City of Portland, Maine - Building or Use Permit

Permit No: 04-0556	Date Applied For: 05/07/2004	CBL: 142 D004001
------------------------------	--	----------------------------

Location of Construction: 121 Walton St	Owner Name: Rodney Robert J Ii &	Owner Address: 121 Walton St	Phone:
Business Name:	Contractor Name: Robert Rodney & Son	Contractor Address: 27 Felicia Ln. Portland	Phone (207) 772-9748
Lessee/Buyer's Name	Phone:	Permit Type: Additions - Duplex

Proposed Use: Garage/ Demo 16' x 16' Garage, build 24'x24' foundation for new garage.	Proposed Project Description: Demo 16' x 16' Garage, build 24'x40' foundation for new garage.
---	---

121 Walton Street
Portland, Maine

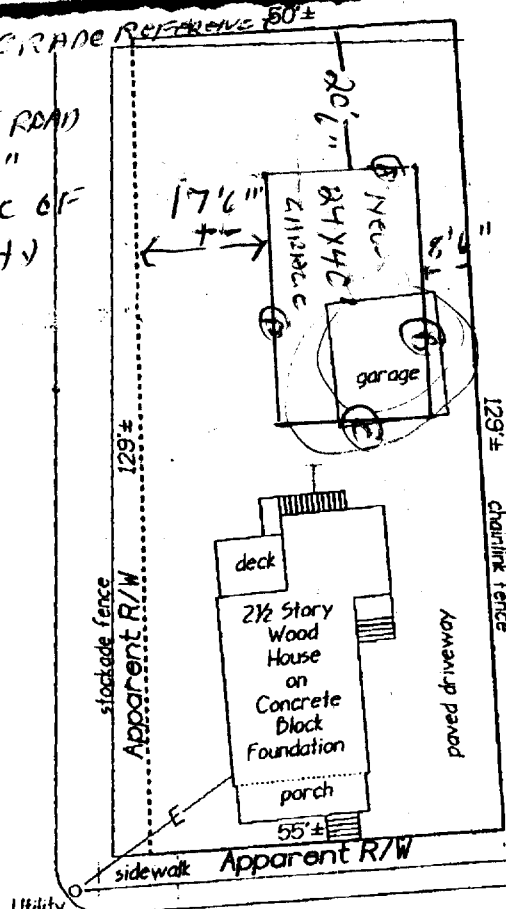
- 1) This permit is approved for demolition and foundation only. It is understood that an application and approval for the structure must be submitted prior to construction. The detached accessory structure can only be a maximum of 18' off the existing grade.
- 2) This property shall remain a two family dwelling. Any change of use shall require a separate permit application for review and approval.
- 3) This permit is being approved on the basis of plans submitted. Any deviations shall require a separate approval before starting that work.
